Your Ref: OWPC16245
Our Ref: EP/145/17/HH 30-10-2017
Please ask for:
Mark Jones

Extend garage & form pitched roof over. Single storey infill extension between enlarged garage & house. Formation of enlargement to existing dormer on SE elevation & addition of pitched roof to existing dormer on NW elevation. Removal of tile hanging from gables & dormers & fitting fibre cement weather board.

9 Nursery Close East Preston

DRAWING TITLE
Proposed Elevations 2 of 2

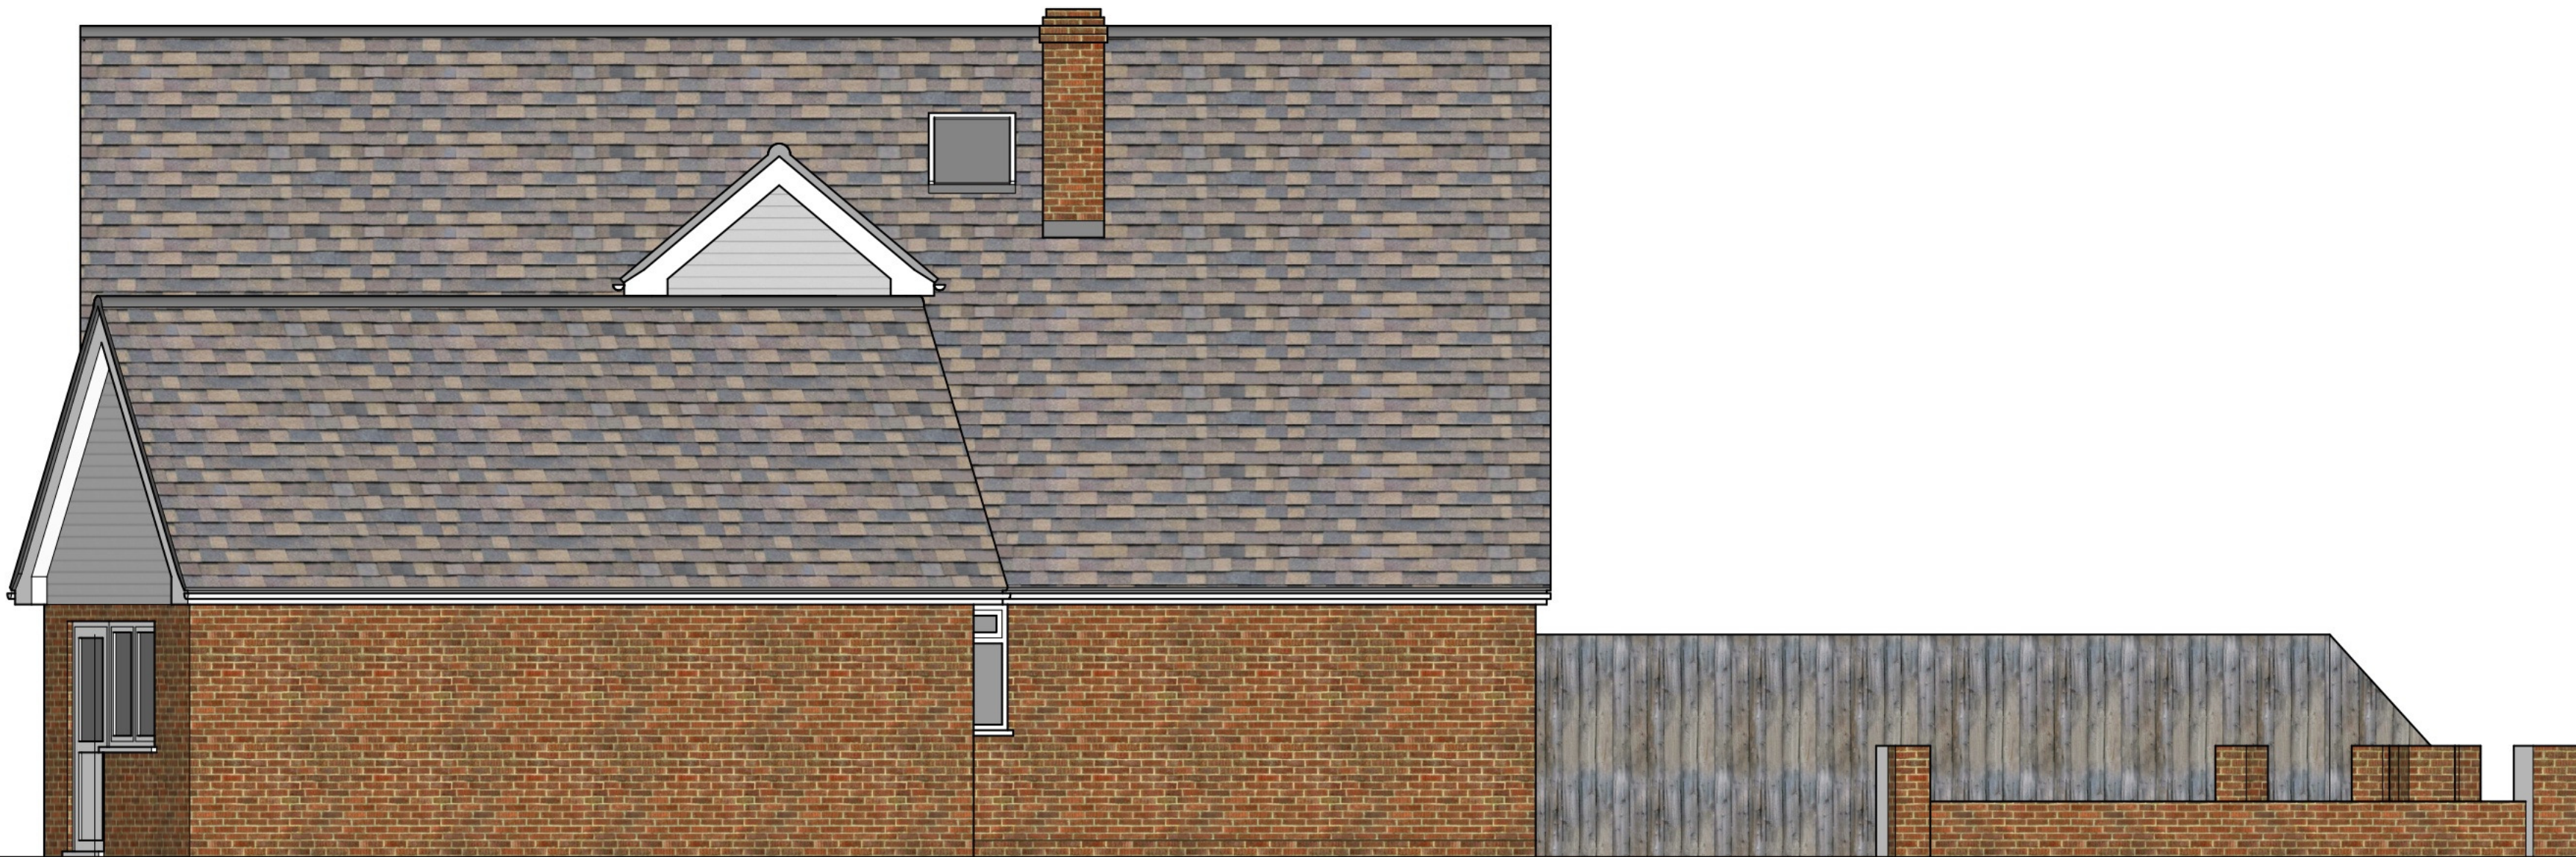
A pitched roof of 5.05m ridge height on the existing garage and garage extension, and pitched roof of 4.7m ridge height on the infill extension will adversely affect our right to light under English Common Law. These proposed pitched roofs serve no useful purpose. Additionally, removal of the tile hanging from gable and dormers and replacement with fibre cement weatherboard is in contravention of the restrictions in the property deeds. Nursery Close is a private road and all houses have tile hanging gables and dormers visible from the road giving a uniform appearance to the street scene.
